Director
Planning & Assessment
Department of Planning, Industry & Environment
GPO Box 39
Sydney, NSW, 2001

Date: 5th October 2019.

Re: Coffs Harbour Council Offices / Cultural / Civic Centre – SSD-10300.

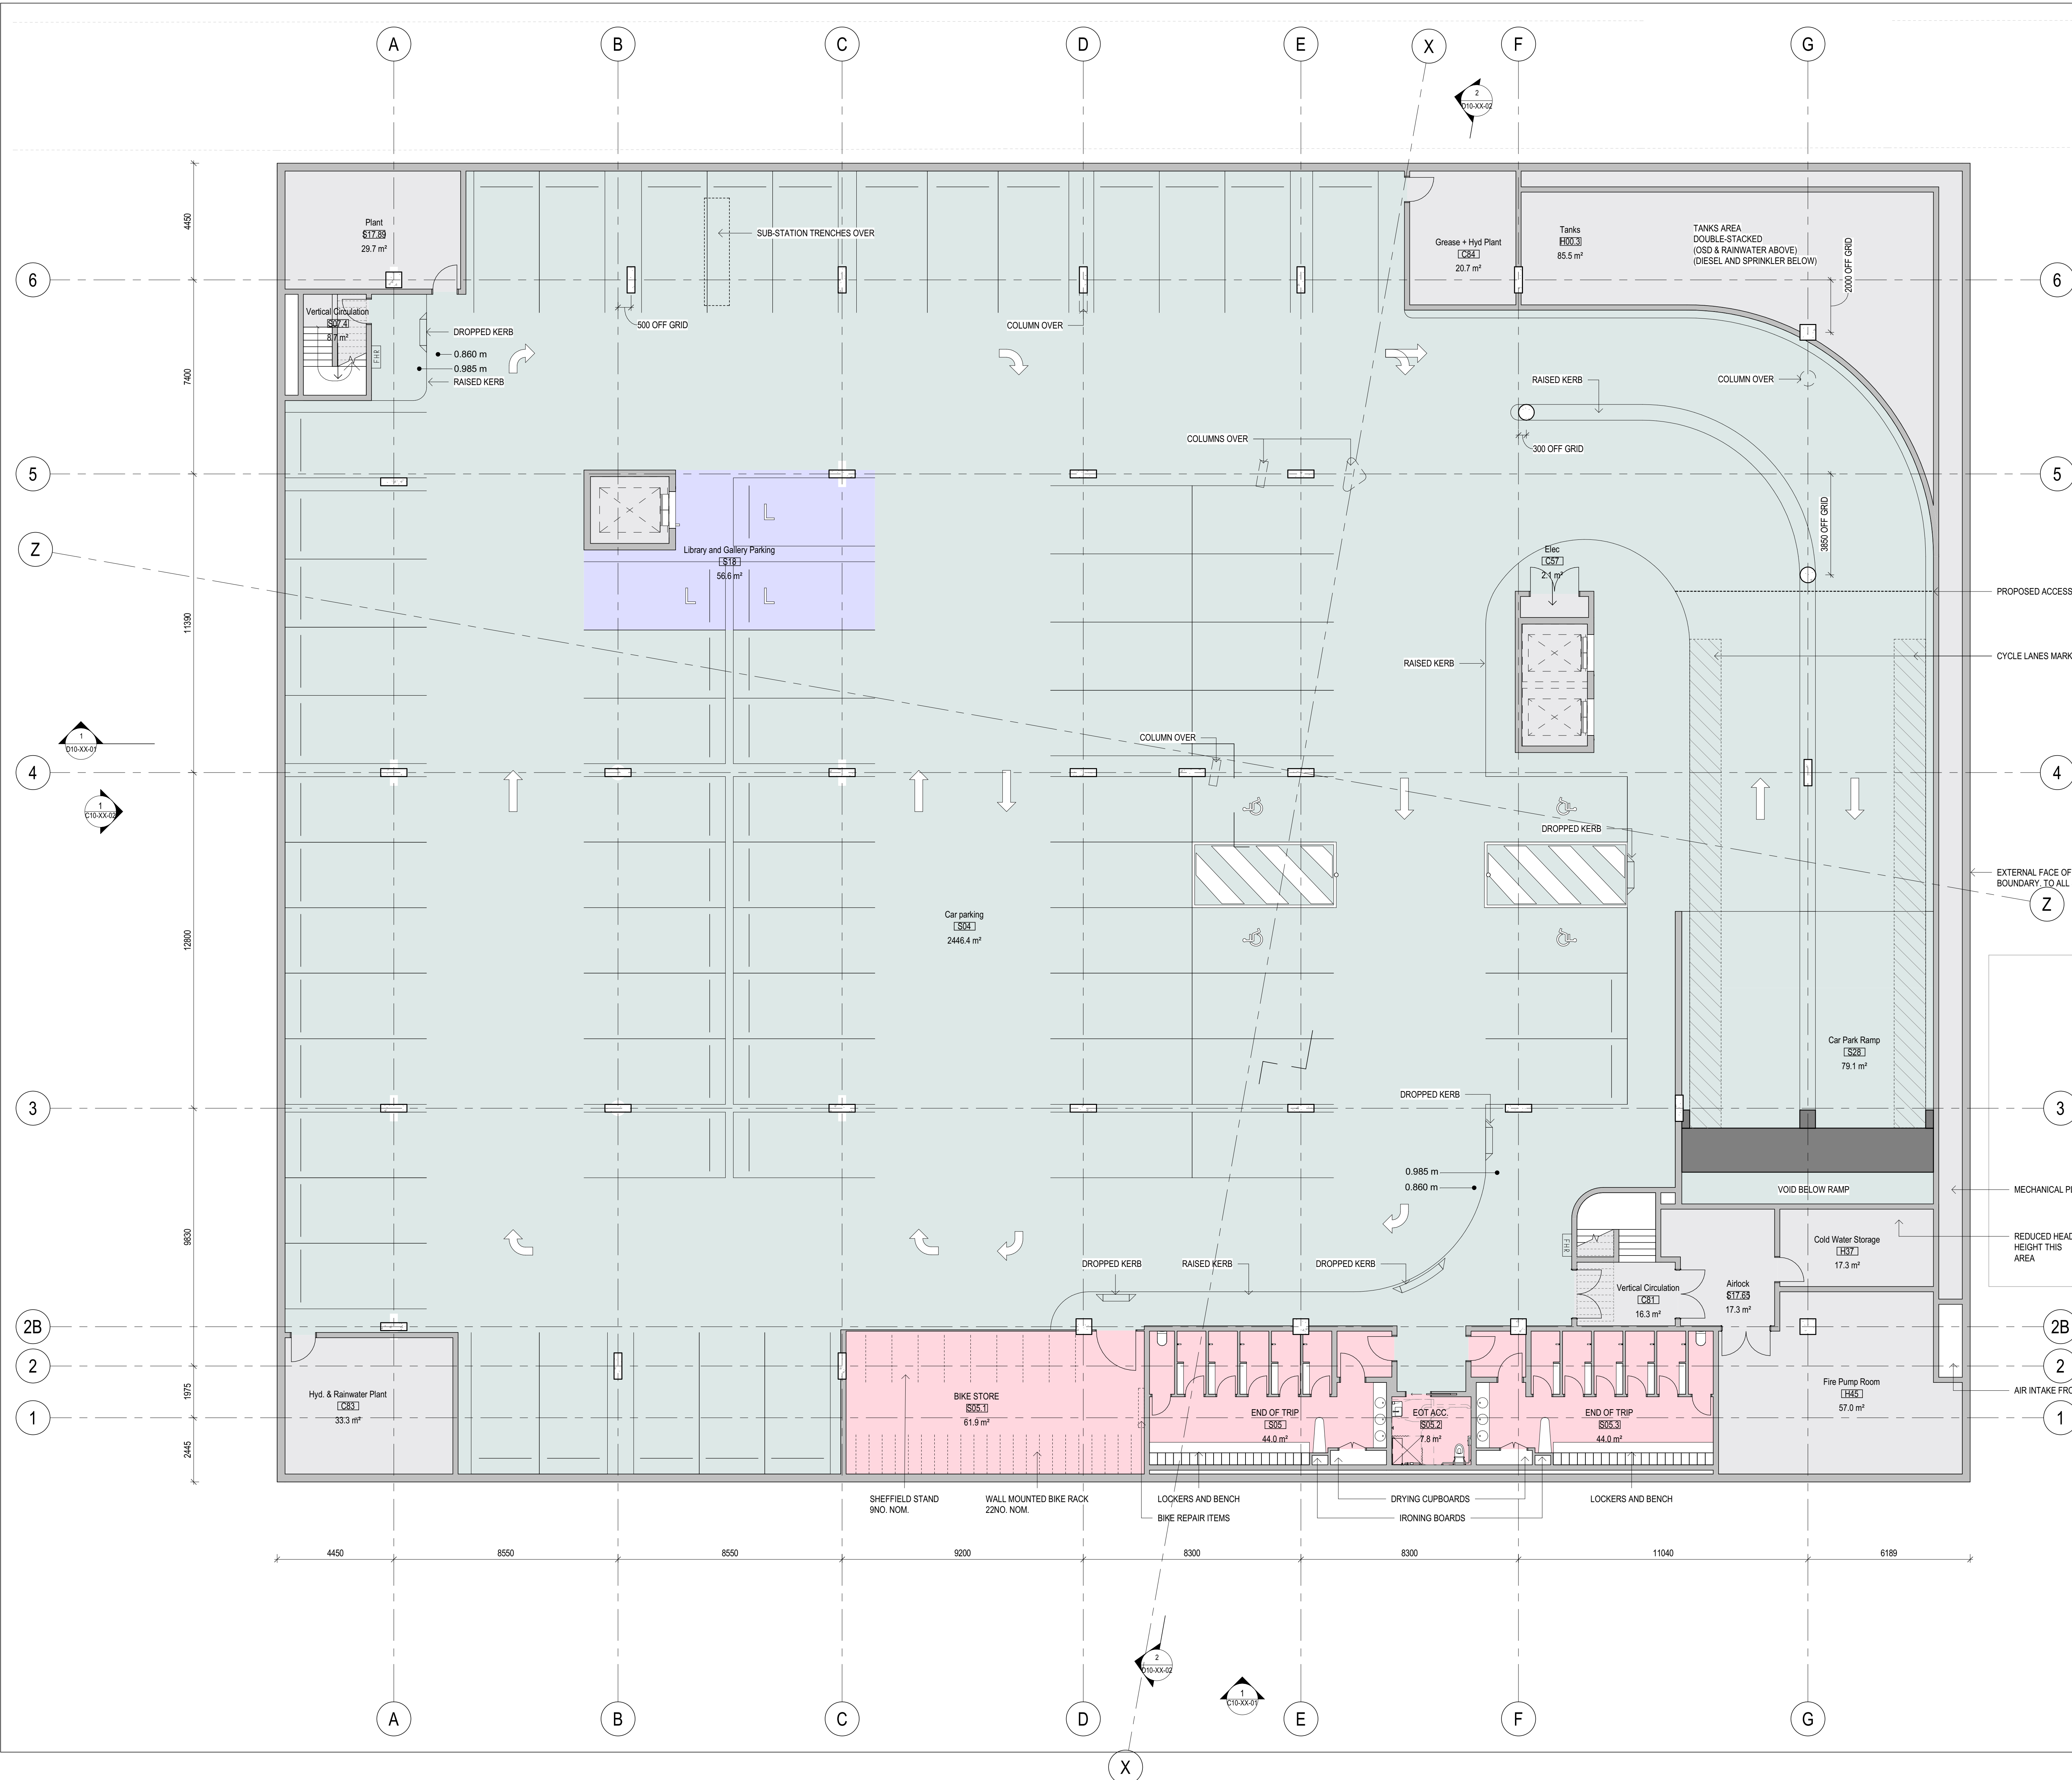
1. **Basement Carpark – Lack of car charging points.**

I cannot see any car charging points in the design documents therefore I assume this has been missed. There should be around 20% car parking spaces available with car chargers. 100% battery electric cars are a rapidly growing segment of the car market and the Council needs to provide this public service. This building will probably last 90 years before it's demolished and replaced so this service must be designed into the scheme now. I recommend Tesla destination chargers for this basement carpark. Electric cars should be encouraged by the Council as good policy and this would improve air quality in the basement carpark as there would be less petrol / diesel fumes and it would improve people's health both in the basement and around the basement carpark ventilation outlets.
